A46 Newark Bypass

Statement of Common Ground with Newark and Sherwood District Council 'NSDC'

**Statement of Common Ground with
Newark And Sherwood District Council**

Regulation Number:	Regulation 5(2)(q)
Planning Inspectorate Scheme Reference	TR010065
Application Document Reference	7.30
Author:	A46 Newark Bypass Project Team, National Highways

- NOTES**
- THIS DRAWING IS TO BE READ IN CONJUNCTION WITH THE DRAFT DEVELOPMENT CONSENT ORDER AND ACCOMPANYING APPLICATION DOCUMENTATION. (TR010065/APP/3.1).

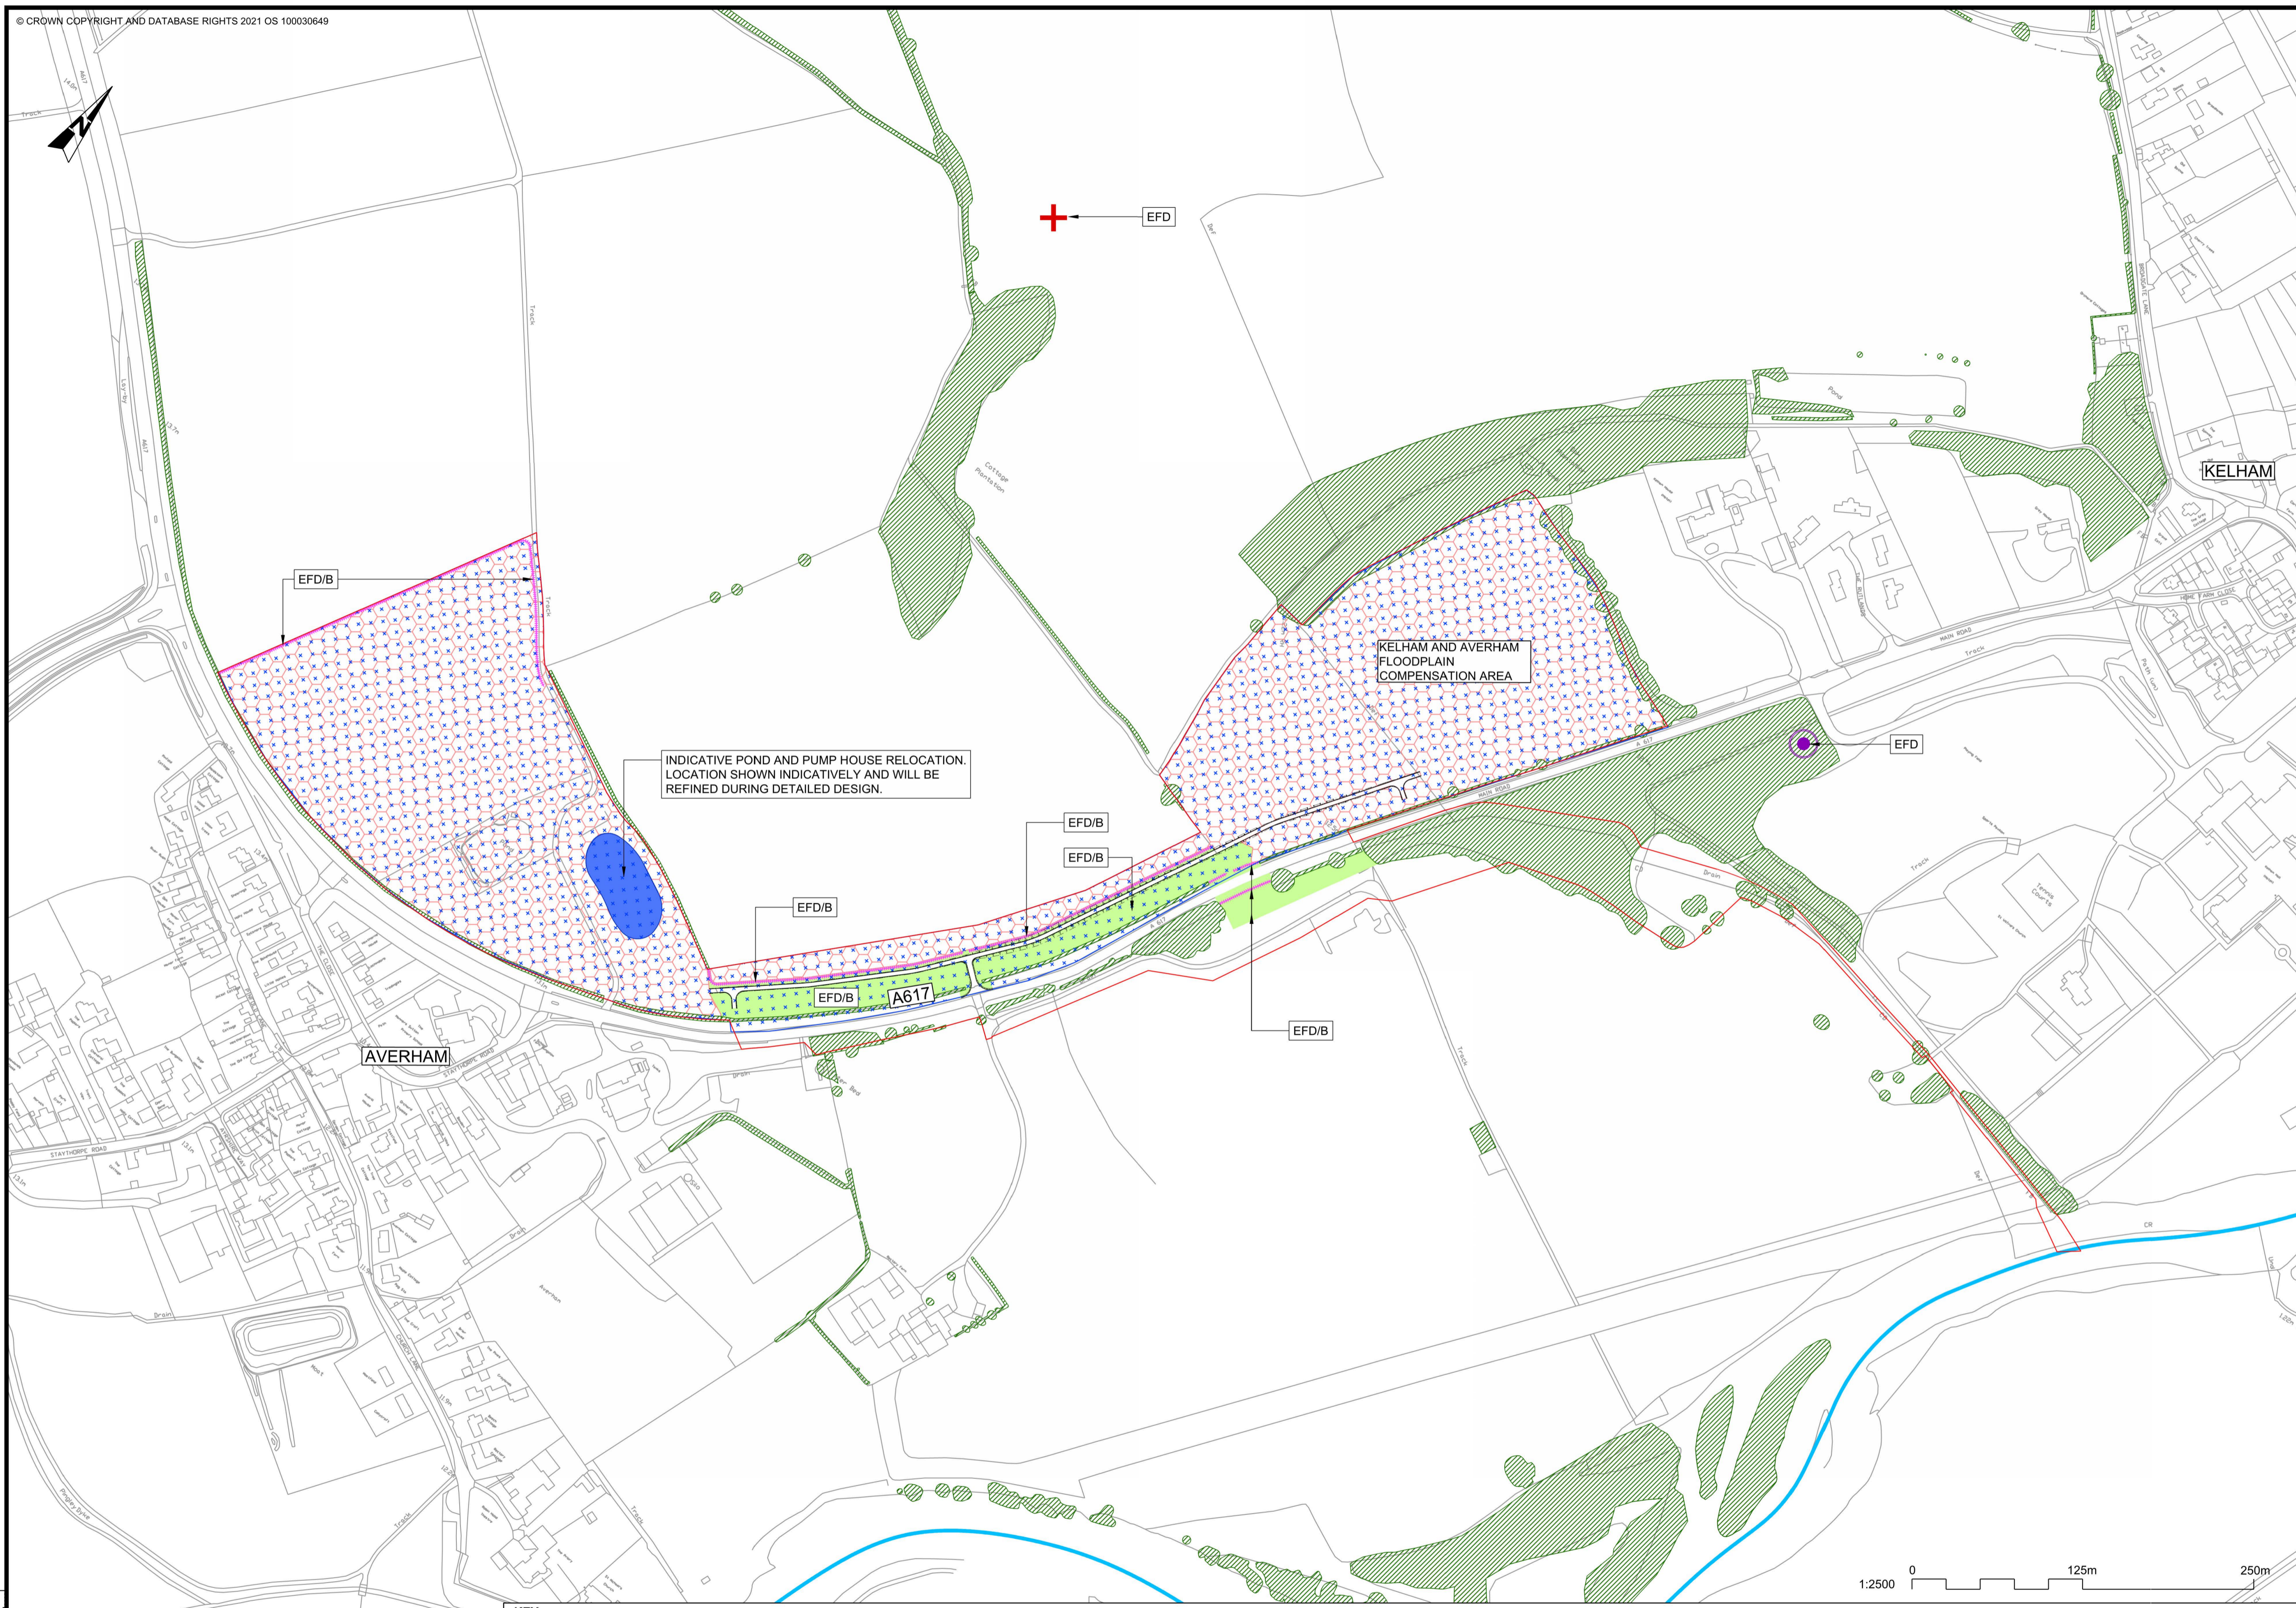
10.	Design (including justification for any flexibility being sought)	<p>Chapter 2 The Scheme of the Environmental Statement [APP-046]</p> <p>6.2 Environmental Statement - Figure 2.3 Environmental Masterplan [AS-026]</p>	<p>Cattle Market flyover</p> <p>On the fly-through video the structure of the elevated over-pass at the Cattle Market junction appears as a stark and imposing concrete structure. This may be in part due to the animation which depicts it as being very bright in colour and therefore standing out vividly. The Council would want to understand proposals to ensure the visible impact of the final structure is minimised and/or mitigated as far as practicable.</p>	<p>Consideration has been given to the aesthetic finish of the structure during the design development to help to reduce the visual prominence of the structure and to reflect finishes on existing structures such as that of Smeaton's Arches just to the north of the new junction. Further details of these can be found within Chapter 2 The Scheme of the Environmental Statement [APP-046] and 6.2 Environmental Statement - Figure 2.3 Environmental Masterplan [AS-026].</p> <p>Planting of trees and shrubs has also been considered and incorporated wherever feasible to help break up the visual mass of the structure, with planting softening the built form and aiding screening over time, particularly from properties such as those in Sandhills Park affording near distance views.</p> <p>The assessment of landscape and visual effects and associated design and mitigation measures are described in 6.2 Environmental Statement - Figure 2.3 Environmental Masterplan [AS-026] and presented in 6.2 Environmental Statement - Figure 2.3 Environmental Masterplan [APP-026].</p>	Under Discussion	16/10/2024
